From: [Early, Shane \(DNR\)](#)
To: [Kelly Bacon \(CD\)](#)
Cc: [Andrews, Garren \(DNR\)](#); [MAUNEY, MARTY \(DNR\)](#); [YOUNG, BRENDA \(DNR\)](#)
Subject: RE: SE-22-00002 Cape - Comment Response
Date: Friday, March 4, 2022 2:28:39 PM
Attachments: [image001.png](#)

Subject: SE-22-00002 Cape - Comment Response

Parcel #19162 Driveway Improvement Extents

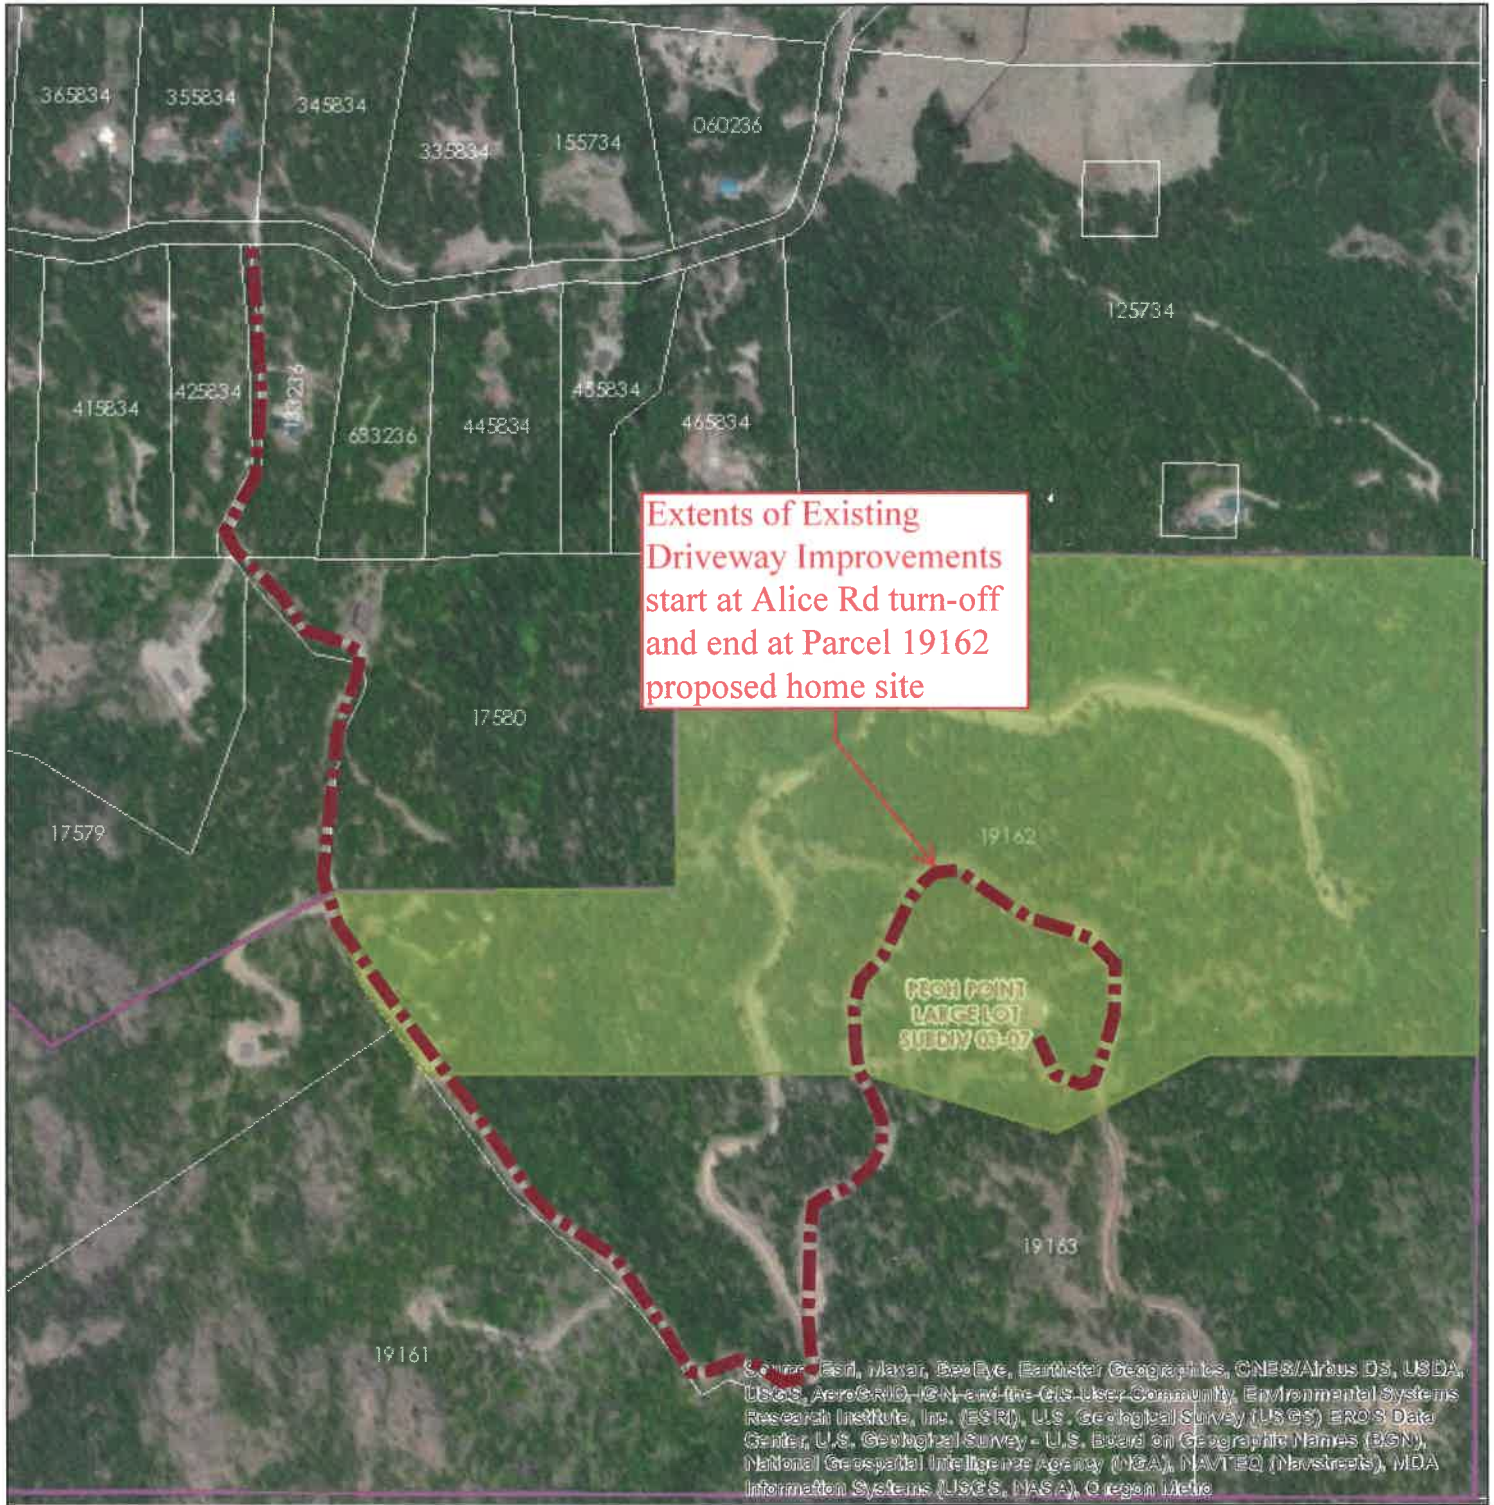
There does not seem to be any ambiguity about the plan to improve the “driveway” by widening and paving, thus this would require an approved Class IV-General FPA prior to ground actions.

However that is simply an observation and does not factor into the need for a FPA or not. Bottom line, the DNR views the proposed improvement of the “driveway” as needing an approved Class IV-General FPA in advance of any ground actions, and the location of the private residence may also need to be captured in an FPA, if there are forest practices involved to create the space for that
